**Proposed Crematorium Highway Improvements
Grevatt's Lane West, Bilsham, Yapton, West Sussex**

Review of Transport Statement
19th September 2019

PBA drawing 128.001.007 Rev D

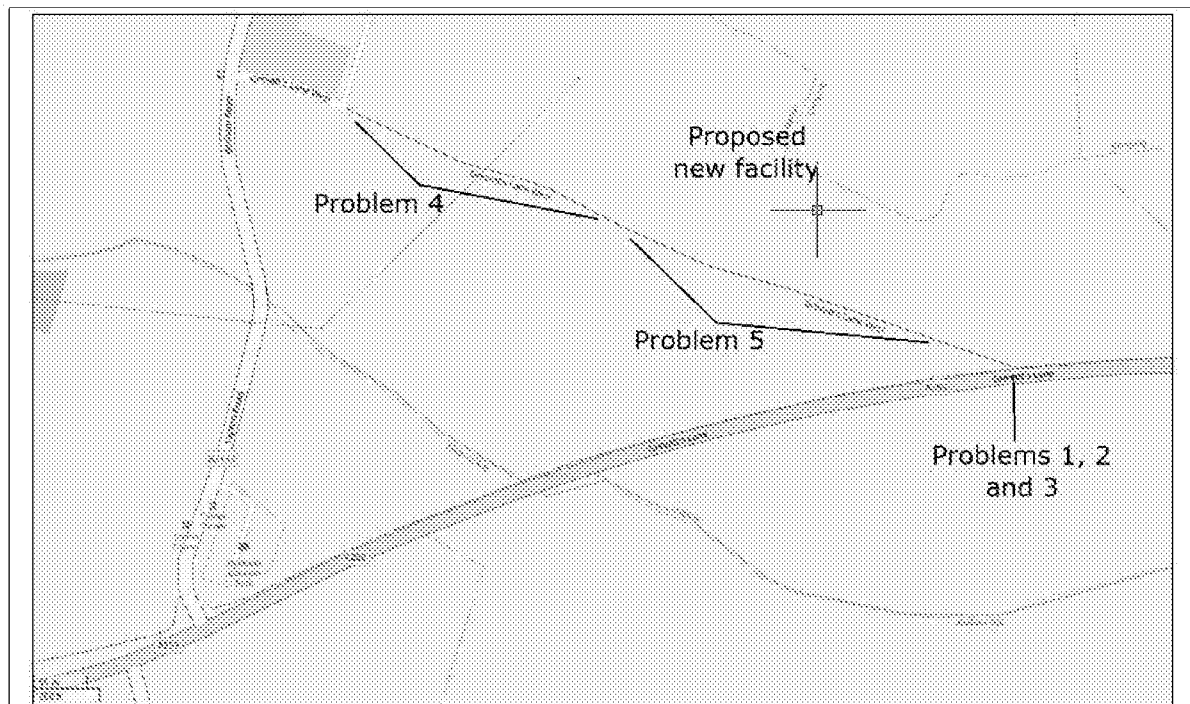
3.3 TS 3.6 – Refers to the narrowing of Grevatt's Lane West just to the west of the proposed new site access and the design drawing PBA drawing 128.001.007 Rev D also shows the provision of a bollard within this narrowing. There is also a farm gate at the wet end of the unmade section of Grevatt's Lane West. Both of which will act as deterrents to the use of Grevatt's Lane West as a through route by motorised vehicles between the A259 and Bilsham Road. Consideration will need to be given to who and how will control these facilities.
